Planning Application Ref: EG/86/17/T

Location: 131 Farnhurst Road, Eastergate

Description of works: Fell 1 No Oak

131 FARNHAMST ROAD

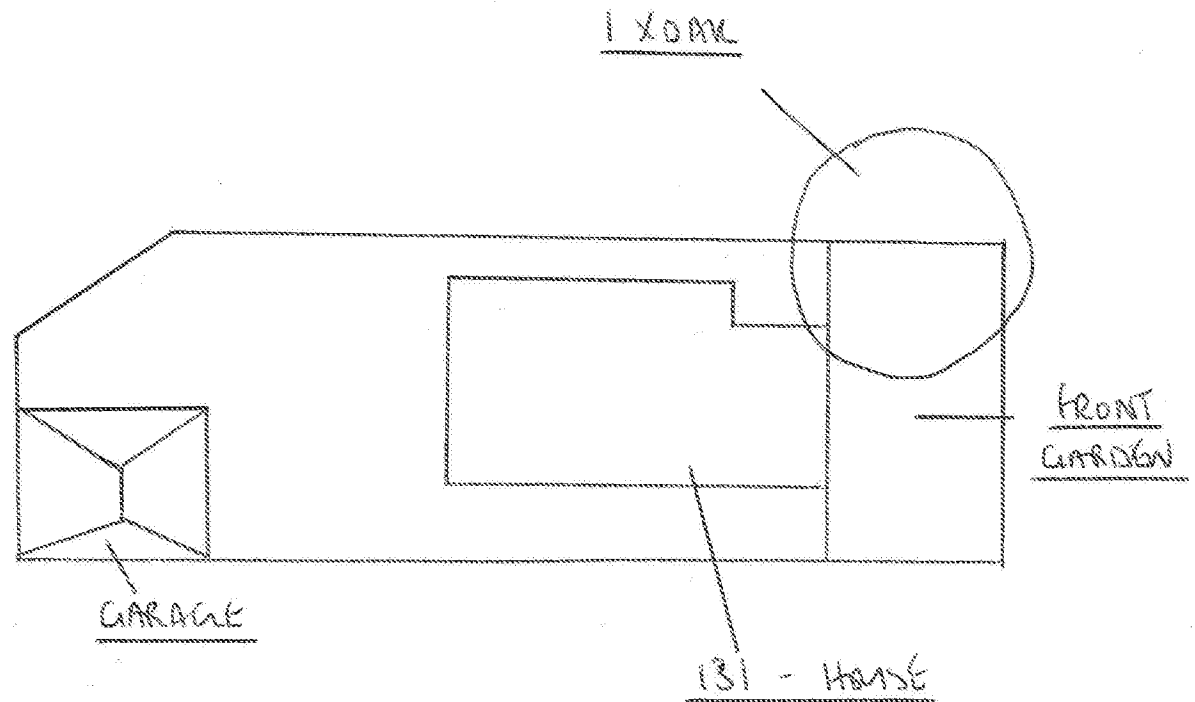
- The concern here is that there are two mature Oaks close together on the road frontage to this site and their plan only shows one tree!
- What we have is a dominant upright trunked tree and a second dominated, suppressed and leaning tree that grows towards the house.
- The upright tree is sound and healthy and contributes significantly to the amenity of this area and it needs to be stressed that whatever work is recommended here it **does NOT apply in any way to this tree**.
- The weaker Oak with the arching lean is **not dangerous** but because of the dominance of the better tree it can only continue to grow out towards the house and cause a nuisance.

- I see no real objection to the removal of the weaker leaning tree on the grounds that the nuisance factor can only get worse and its removal might benefit the better tree beside it.

- I recommend **APPROVAL** for the works as described in the application.
- In this instance we will not be seeking a replacement tree at this location.
